**Consultation Response from KC,
Lead Local Flood Authority**

2023/91236 White Syke Farm, Marsden Lane, Marsden, Huddersfield, HD7 6AF

Erection of lean-to car port to western gable end (Listed Building)

Date Responded: 15/06/2023.

White Syke Farm- Site Plan-Proposed Car Port  
(showing location of water course).

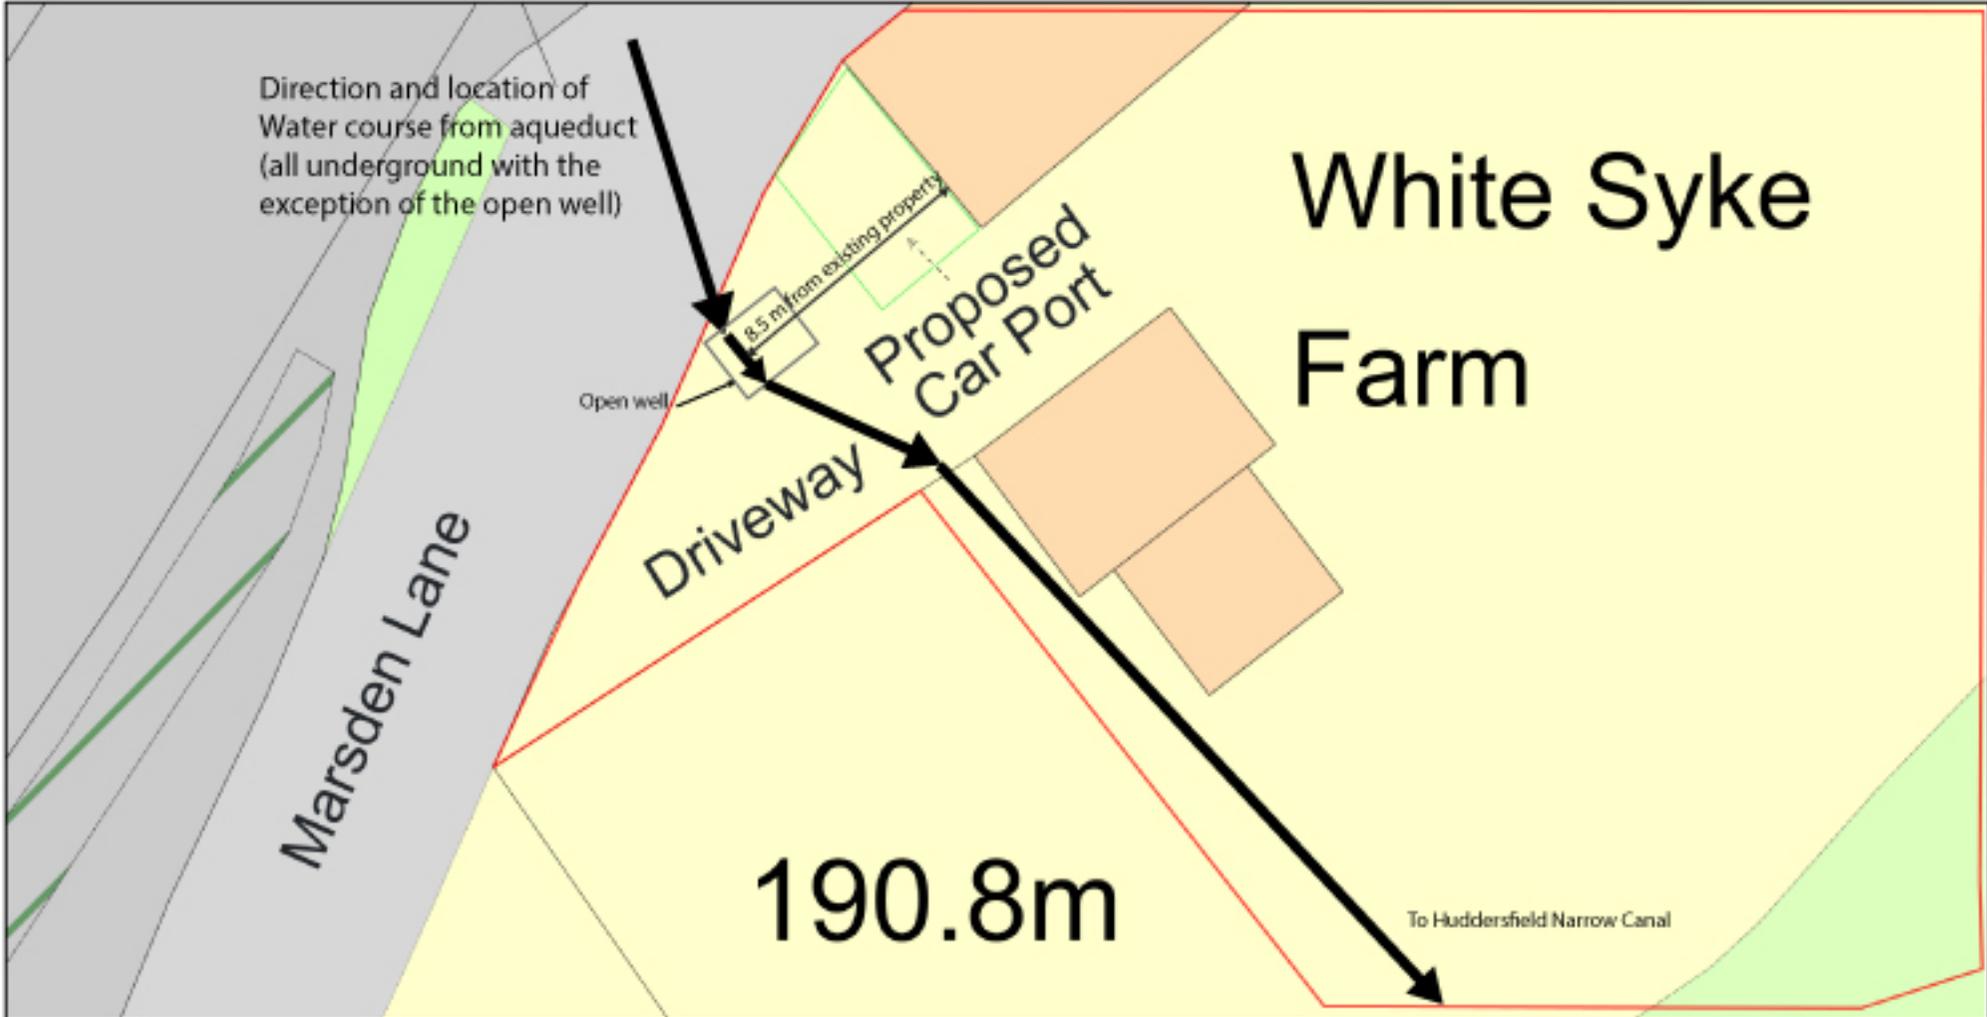
The proposed car port appears to be more than 3.0m from the centreline of the culvert (the minimum easement requirement) serving the aqueduct. Therefore the LLFA confirms that there is no objection to the proposed development.

Kirklees Flood Management and Drainage as the Lead Local Flood Authority, SUPPORTS this application and has no recommended drainage conditions.
